TOWN AND COUNTRY PLANNING ACT 1990

Reference:	H16-0748-23	Date of Decision:	16th November 2023
Applicant:	Newton Penstar Ltd. 3 Church St Carlby Lincs PE9 4NB		
Location:	Willow Villa 10 Green Lane Spalding		
Description:	Change of use of two-storey garage/annex to two studio flats - Part Retrospective

South Holland District Council hereby give notice that this application has been REFUSED for the above proposal for the following reason(s):

PROPOSED FF PLAN
SCALE 1:100

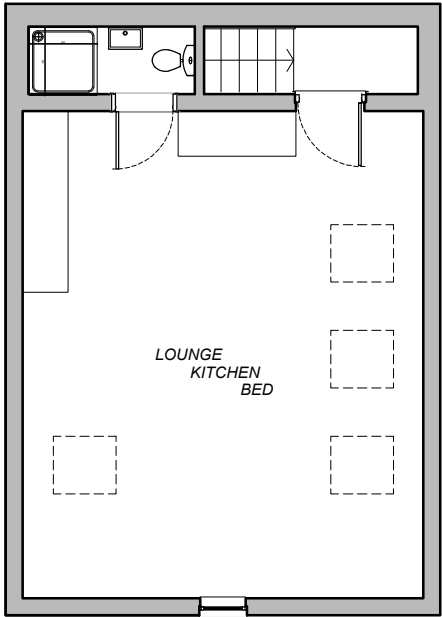
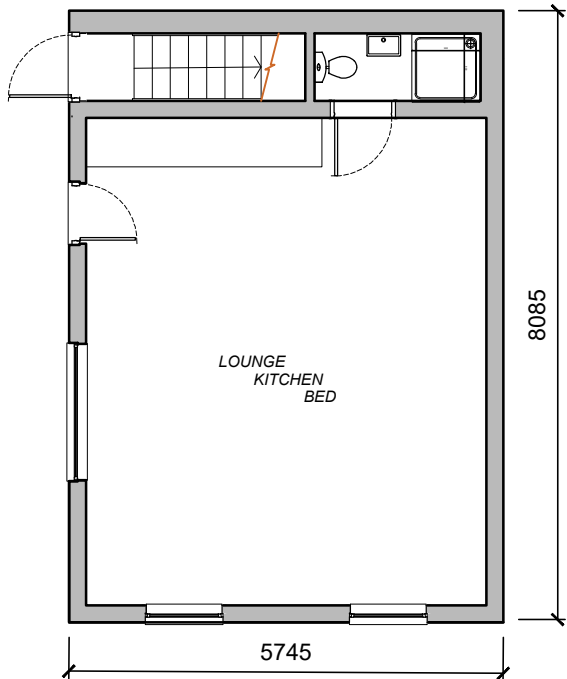
- 1 It is considered that the proposed studio flats would not provide an adequate level of amenity for future residents. The flats fall below the 'Technical housing standards - nationally described space standard' (March, 2016), furthermore no external amenity area is provided for future residents. The proposal is therefore considered to be contrary to Policies 21, 2 and 3 of the South East Lincolnshire Local Plan 2019.
- 2 The proposed development if approved would provide an insufficient level of overall off-street parking provision. Furthermore the applicant has failed to provided any cycle parking provision or waste storage facilities for future residents This is unacceptable and contrary to Policies 2 and 36 of the South East Lincolnshire Local Plan 2019.
